From: Contact Centre (CRM) <contact@ribblevalley.gov.uk>
Sent: 31 December 2025 19:06
To: Planning
Subject: Planning Application Comments - 3/2025/0960 FS-Case-779700231

Planning Application Reference No.: 3/2025/0960

Address of Development: 8 Hammond Drive, Read, BB12 7RE

Drawing Title
Proposed Elevations

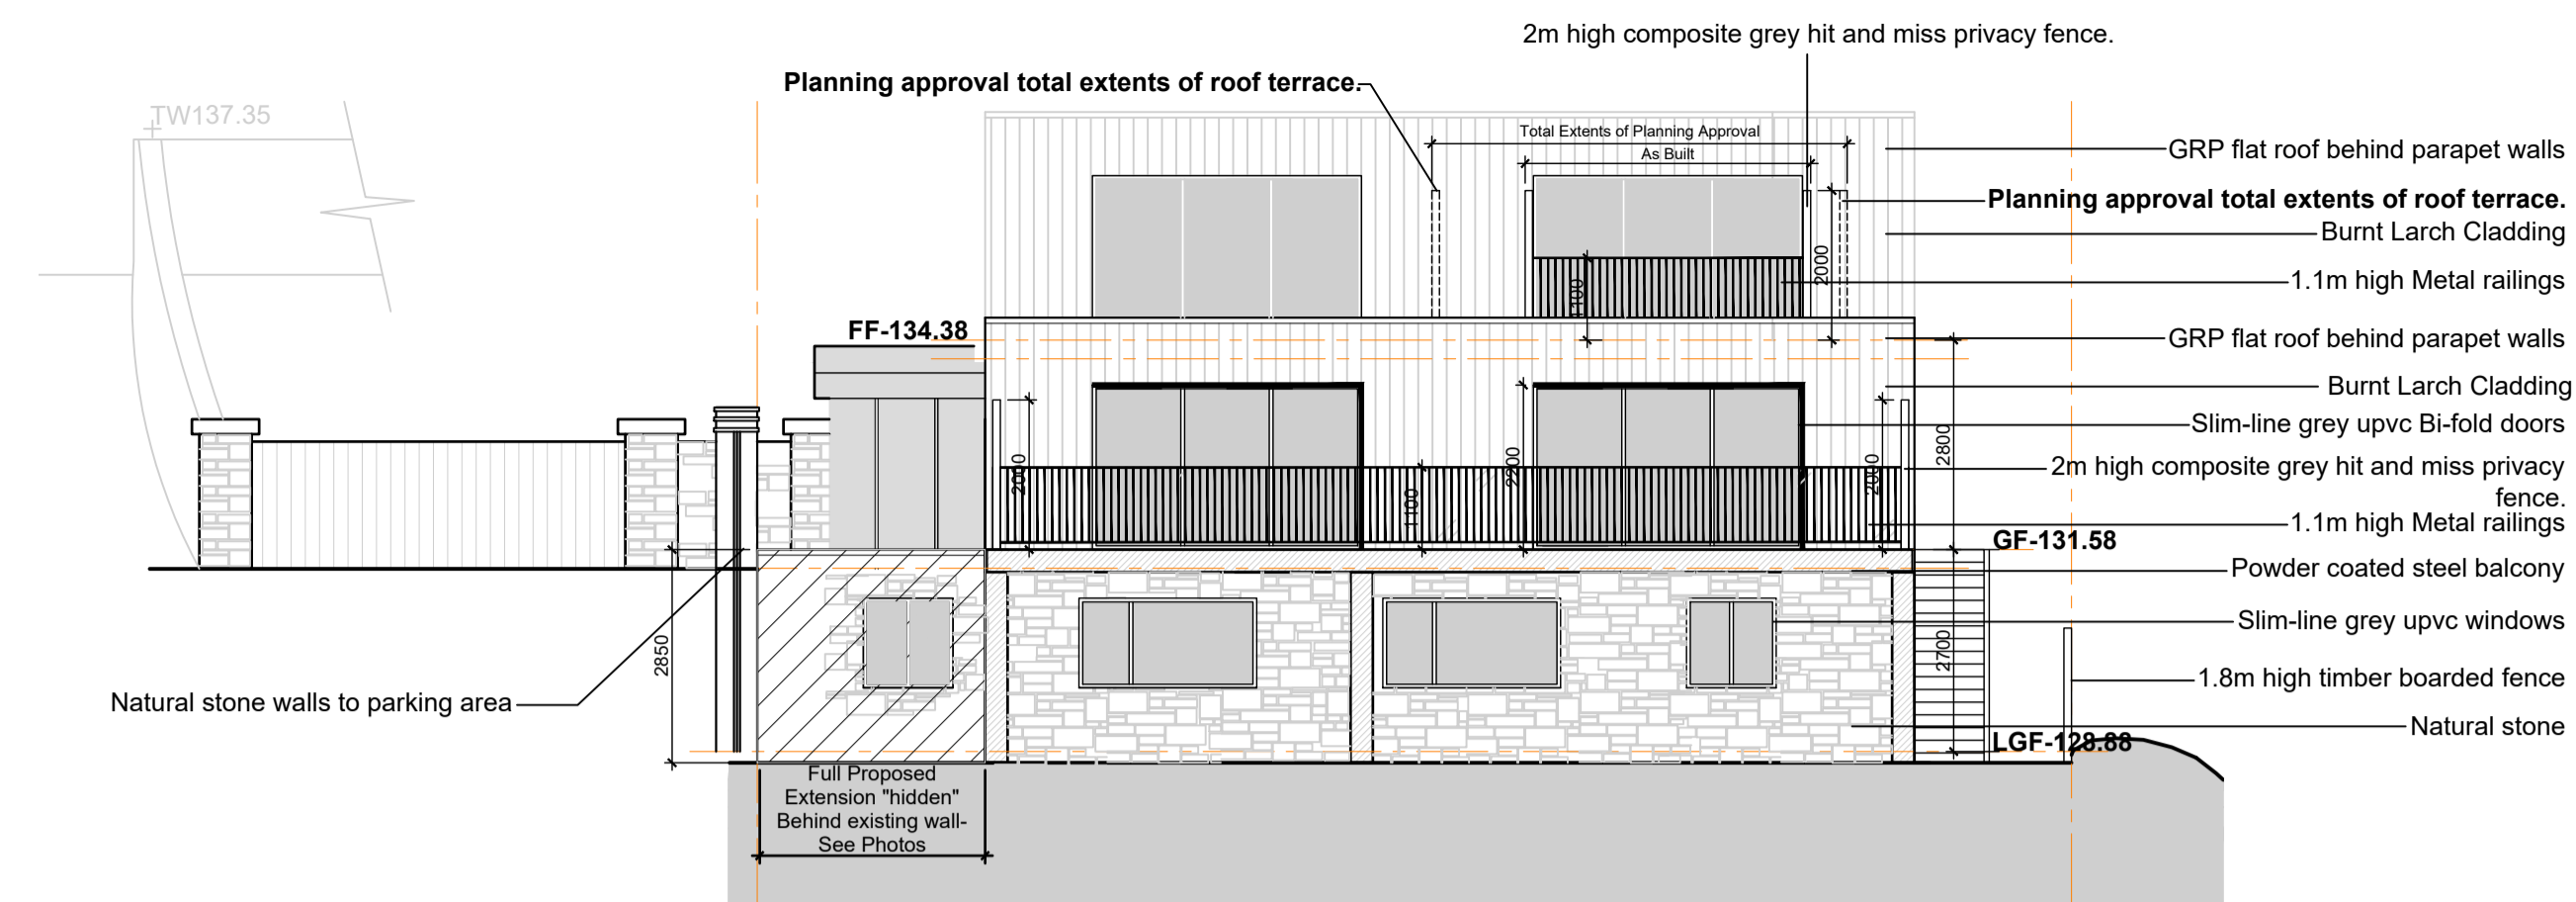
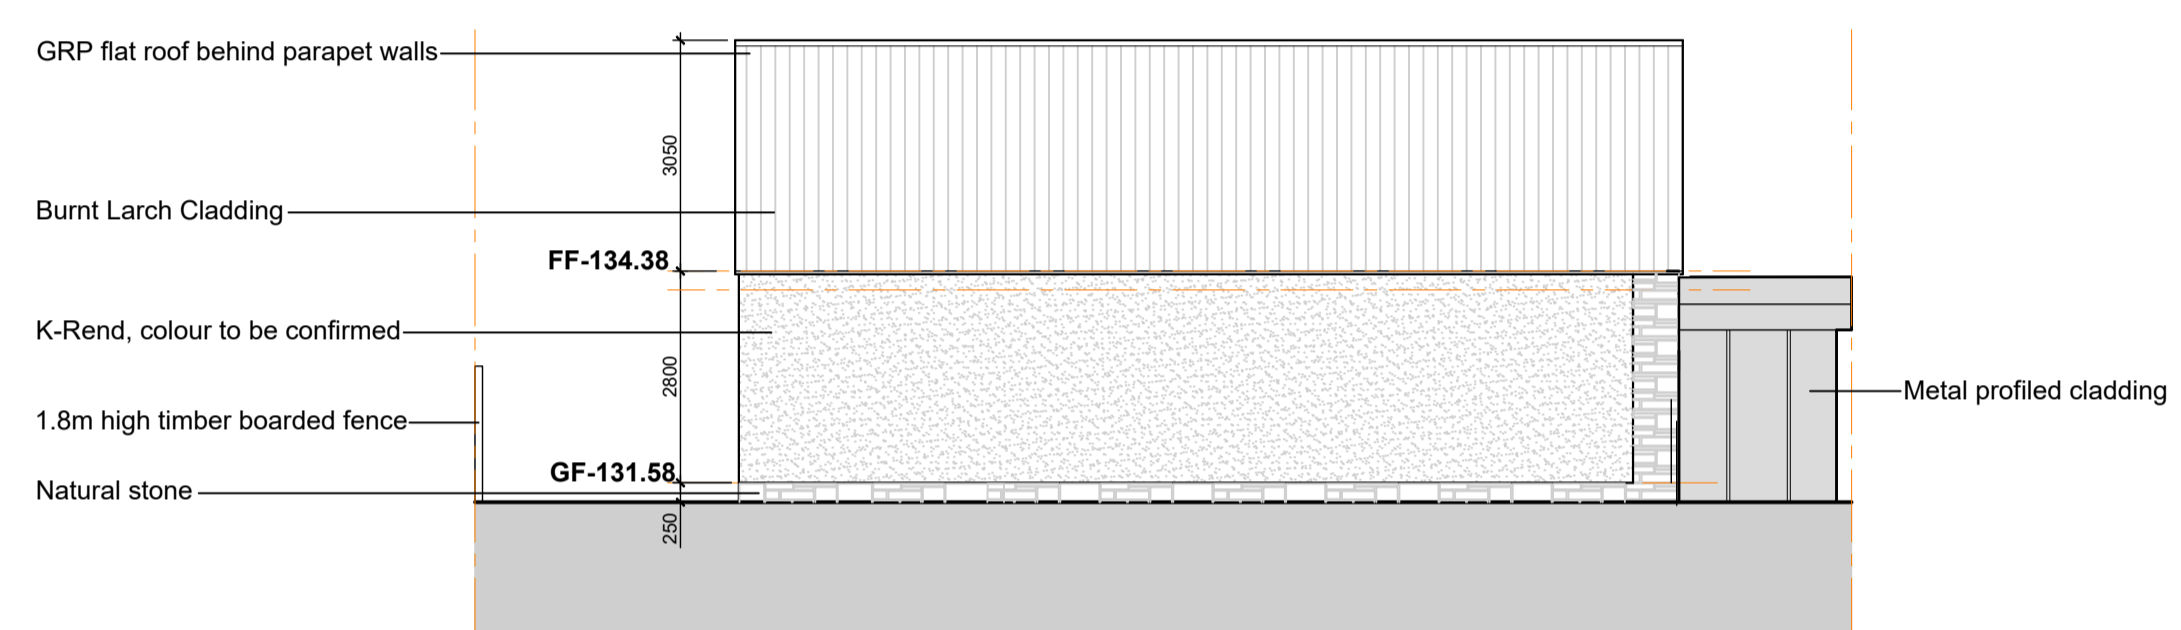
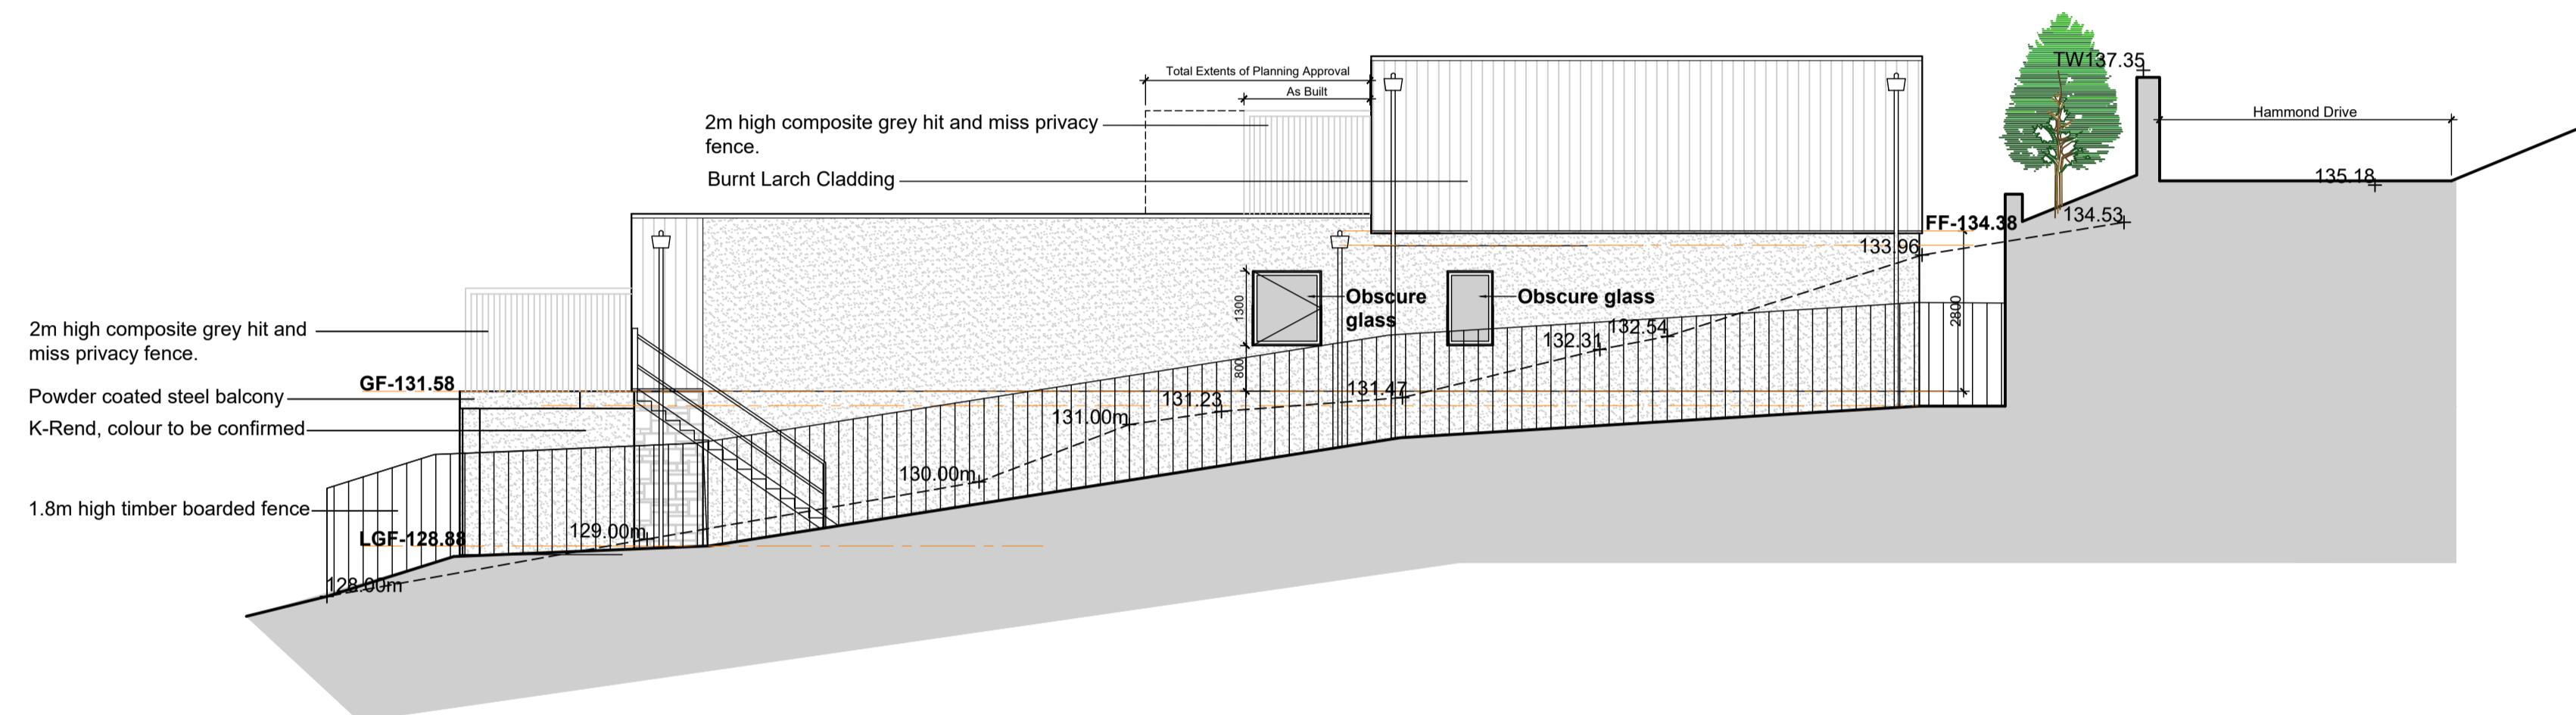
Comments: This is now the second time an application for amendments to approved plans has been made to which we object because it impacts directly on immediate neighbours. The builder has failed to install 1.8m opaque glazing to provide privacy to the balcony sides at both levels, contrary to the approved plans.

There is instead a "hit and miss" version which does not protect privacy [REDACTED]. There are children who use the garden and we are very concerned about their lack of privacy, as well as [REDACTED]. The "hit and miss" panelling is also unsafe because it is rattling when the wind blows because there is no supporting cross bar. At the front, contrary to the approved plans a toughened glass balustrade has also not been installed.
